From: Amanda Scholes on behalf of Planning.Responses
Sent: 21 May 2019 09:21
To: Planning Scanning
Subject: FW: Response To Application Number EG/22/19/OUT at Boweries Barnham RoadChichesterPO20 3RT
Attachments: Response_EG-22-19-OUT.pdf; 1815-101-P03 - Proposed Site Layout Plan 03-12-18.pdf; MBSK190426-01.pdf; Transport - 26-03-2019.pdf

Please find attached the consultation response from the Local Highway Authority regarding the outline planning application (EG/22/19/OUT) for the Boweries on Barnham Road, in Eastergate.

TO:	Arun District Council FAO: Michael Eastham
FROM:	Stephen Gee WSCC - Highways Authority
DATE:	15 April 2019
LOCATION:	<u>Boweries Barnham</u> Road Chichester <u>PO20 3RT</u>
SUBJECT:	<u>EG/22/19/OUT</u> Outline application with some matters reserved for the erection of 28 No. dwellings, access, landscaping & associated works (resubmission following EG/42/18/OUT).
DATE OF SITE VISIT:	3/8/18
RECOMMENDATION:	More Information
<u>S106</u> CONTRIBUTION TOTAL:	£ See below for breakdown.

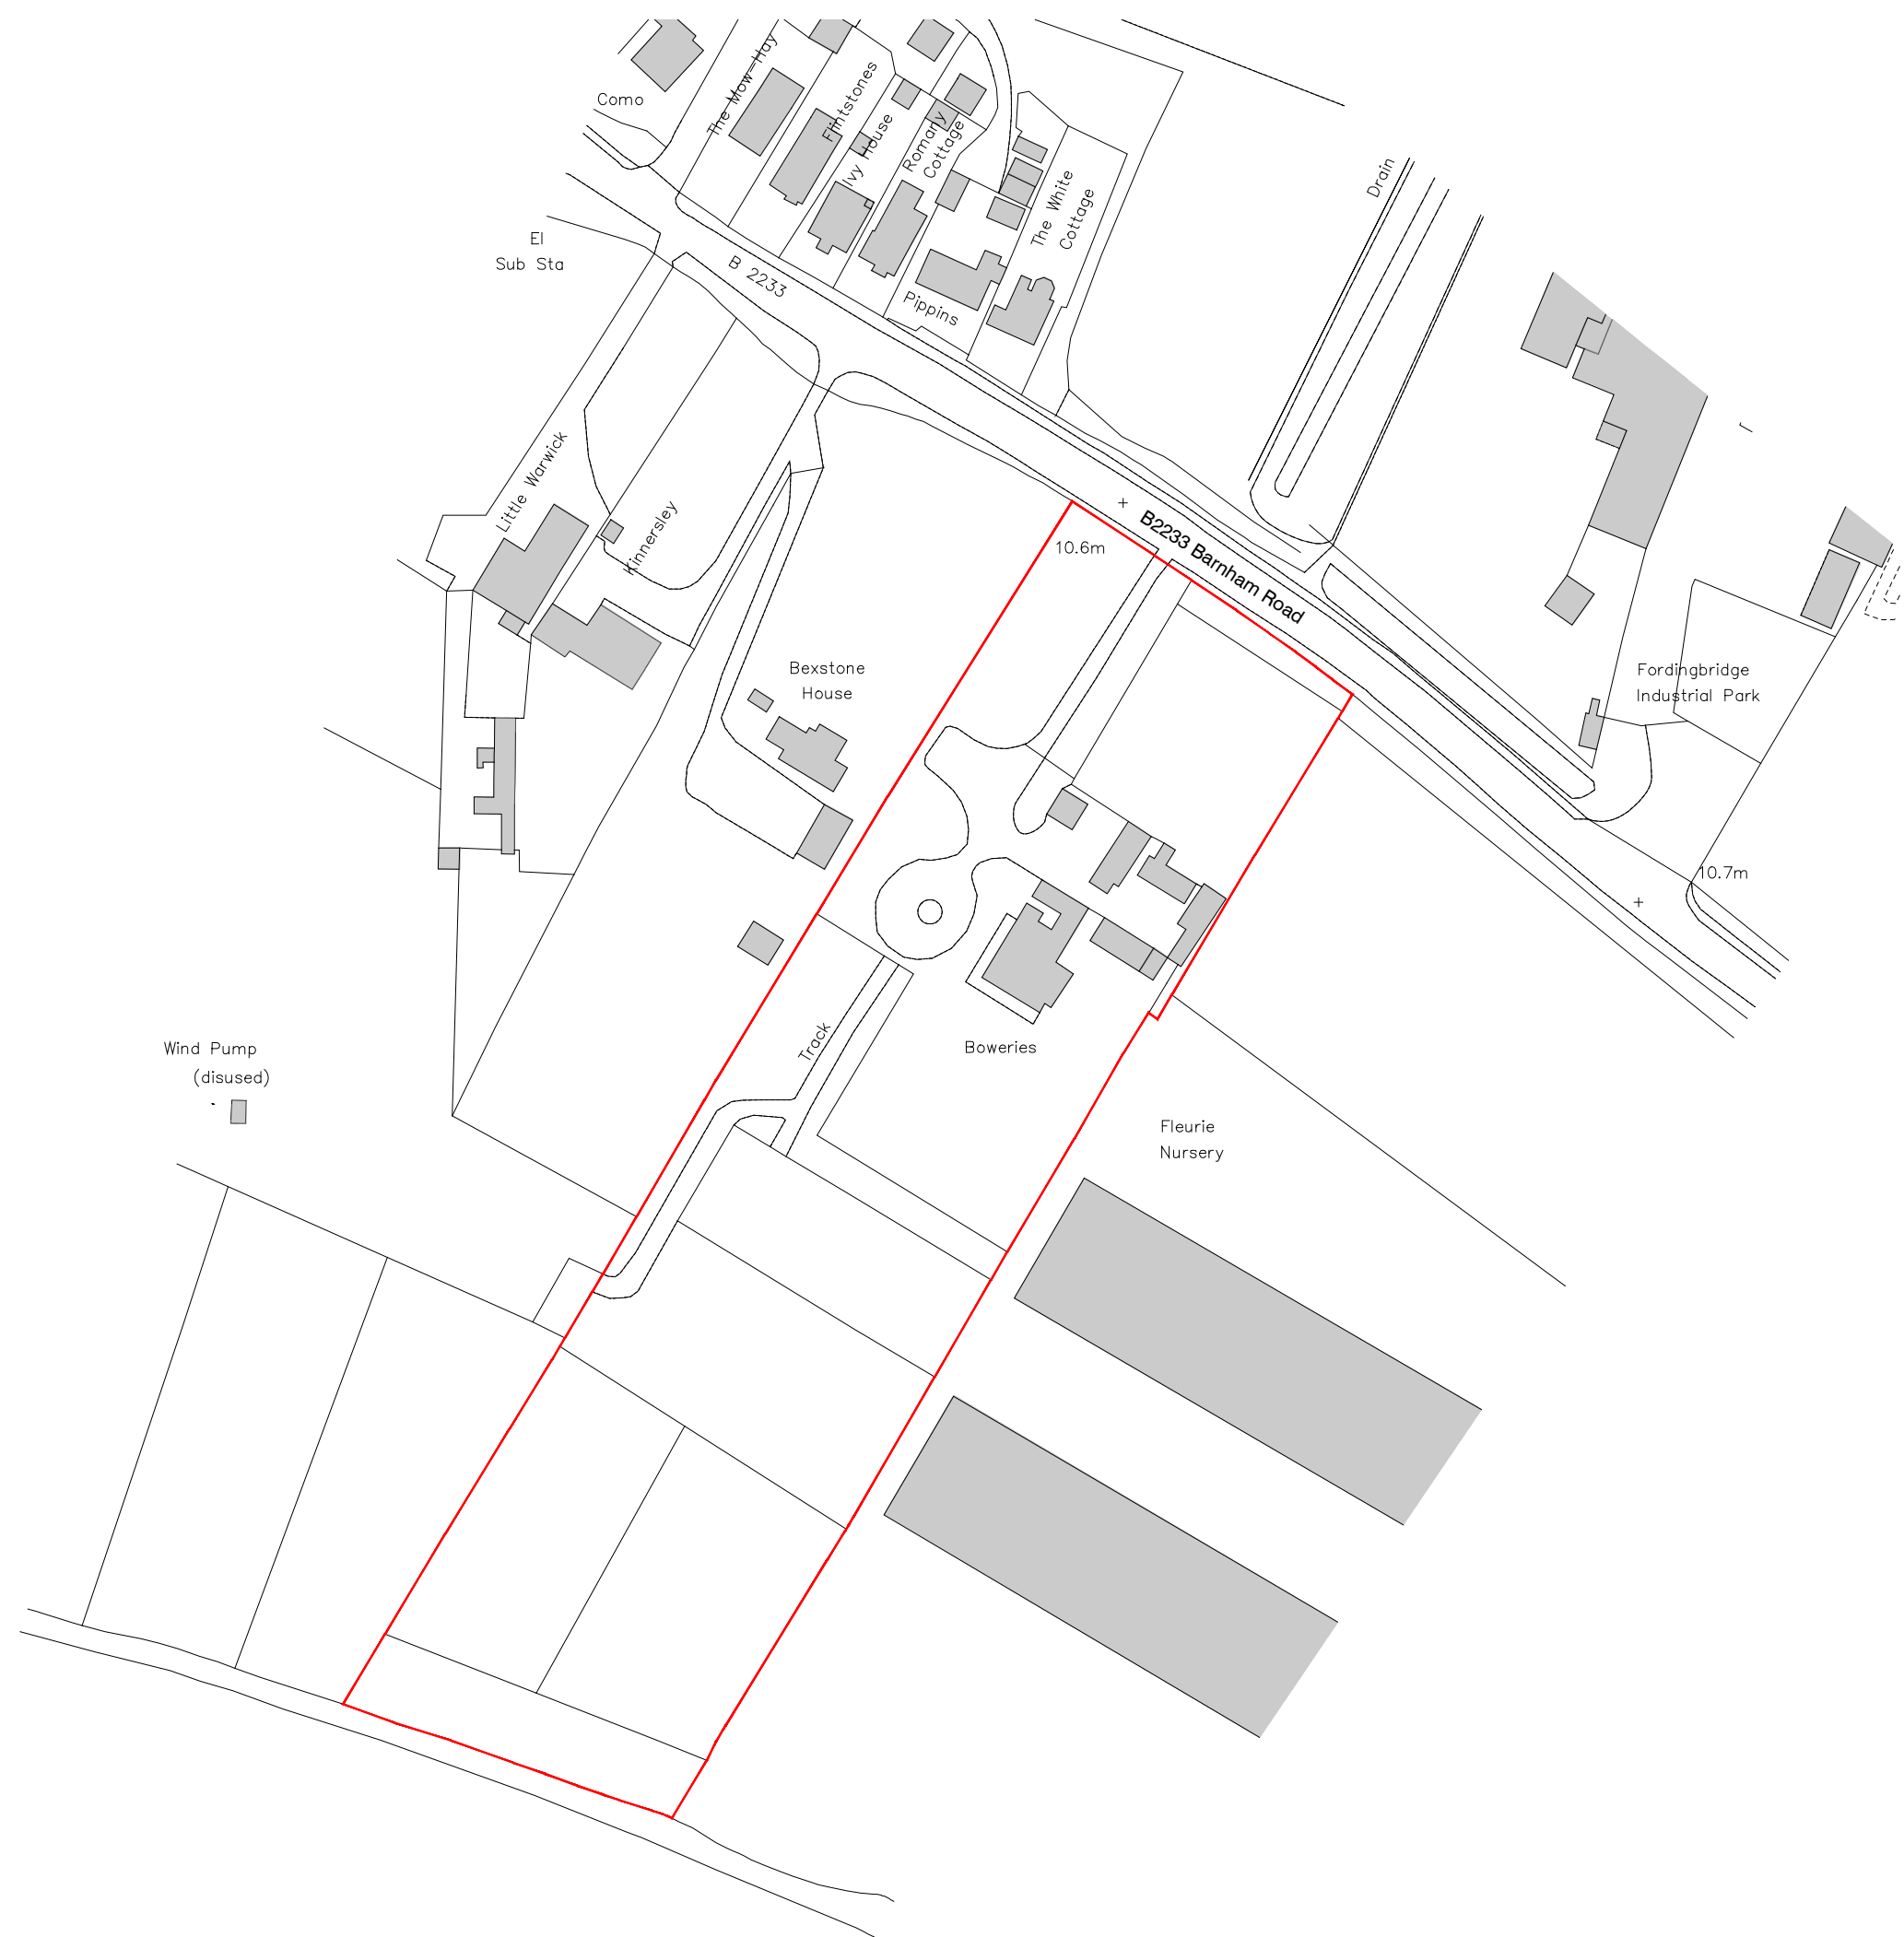
The applicant proposes a total of 34 parking spaces including the provision of 10 garage spaces. When comparing this to the WSCC parking demand calculator this would give a significant under supply of parking within the site and concerns would therefore be raised.

The proposed site layout plan indicates the provision of a footpath adjoining Barnham Road to the site boundaries to the east and west, pedestrian crossing point's incorporating dropped kerbs and tactile paving would be required to improve pedestrian connectivity.

- updated transport statement which confirms the correct number of car parking spaces provided as part of the outline scheme to correlate with the 62 parking spaces shown on the proposed site layout plan
- tracking for the northern head turning

FIGURE 1.4

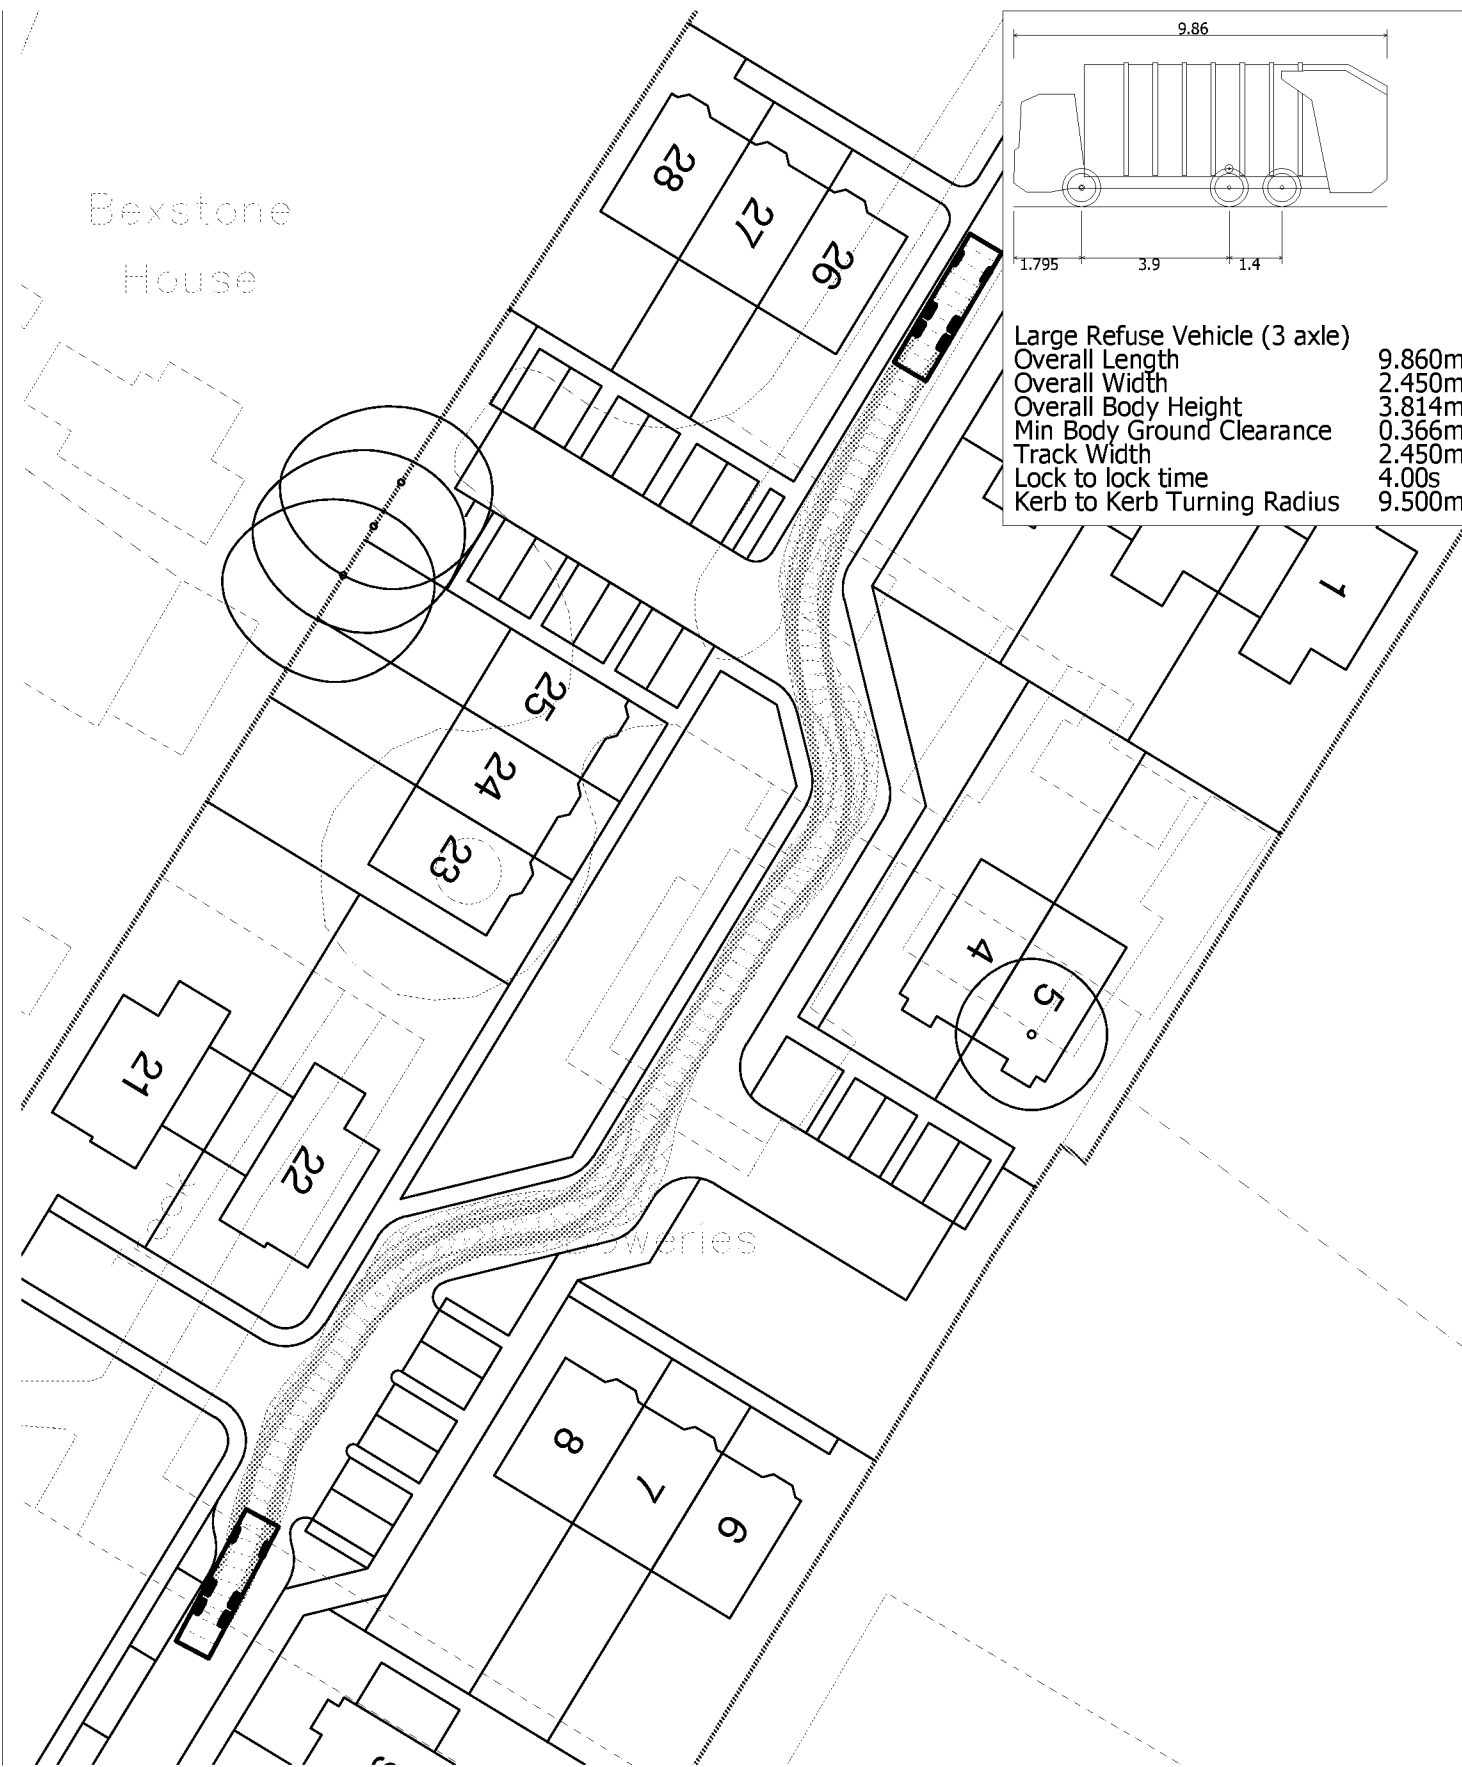
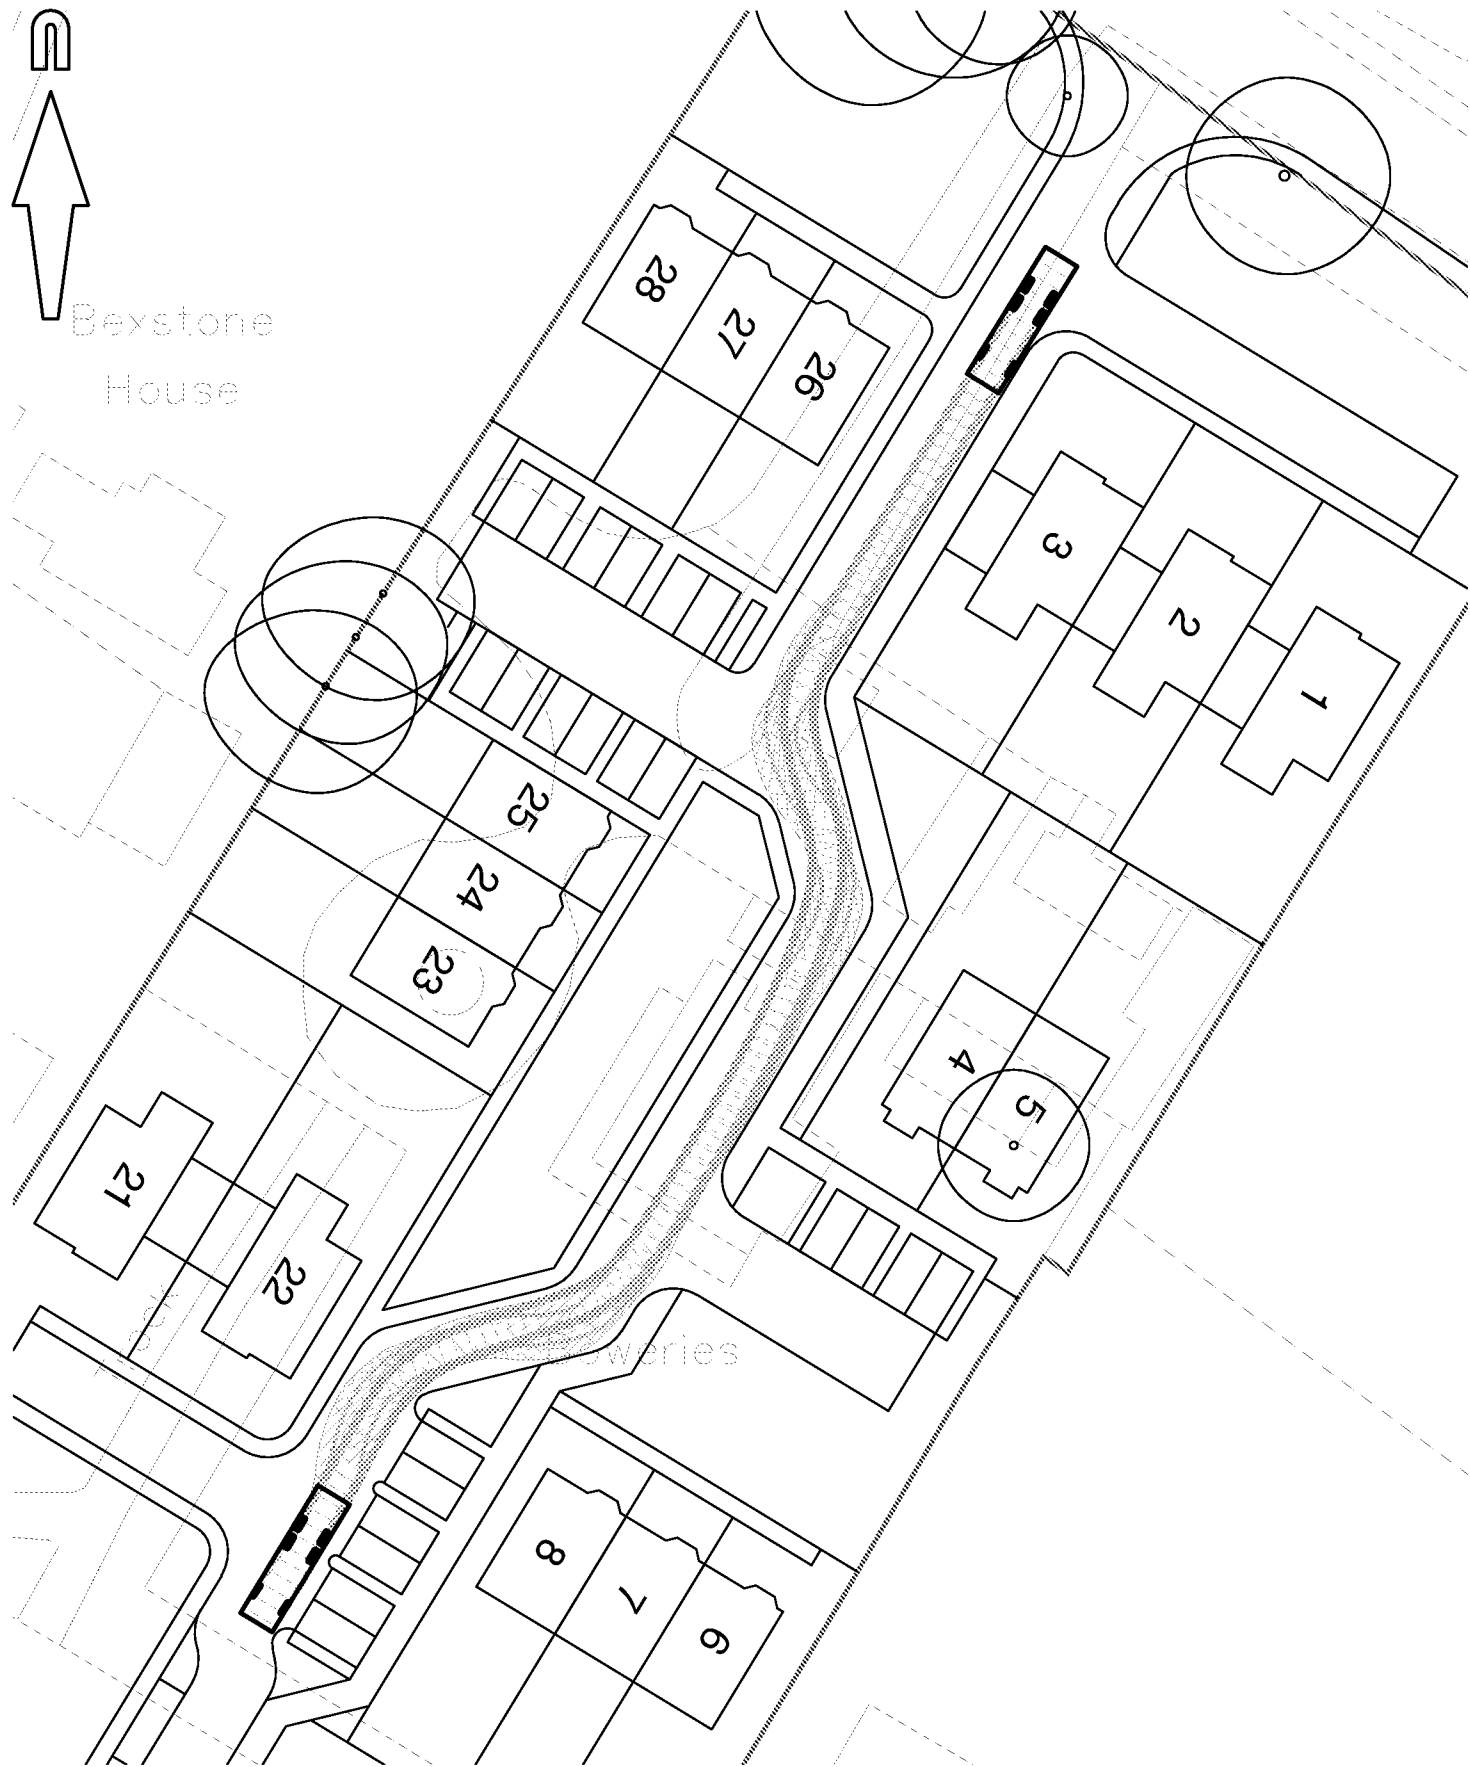
Vehicle tracking has been provided and shows the site access can accommodate a large refuse vehicle however no vehicle tracking has been provided for a southern turning head.

Whilst the application is outline only further information is required to establish if the site can accommodate the provision of a satisfactory turning head enabling refuse vehicles to enter and exit in a forward gear and accommodate the levels of parking as set out in the WSCC parking demand calculator. The applicant should also confirm acceptance of the strategic infrastructure contribution.
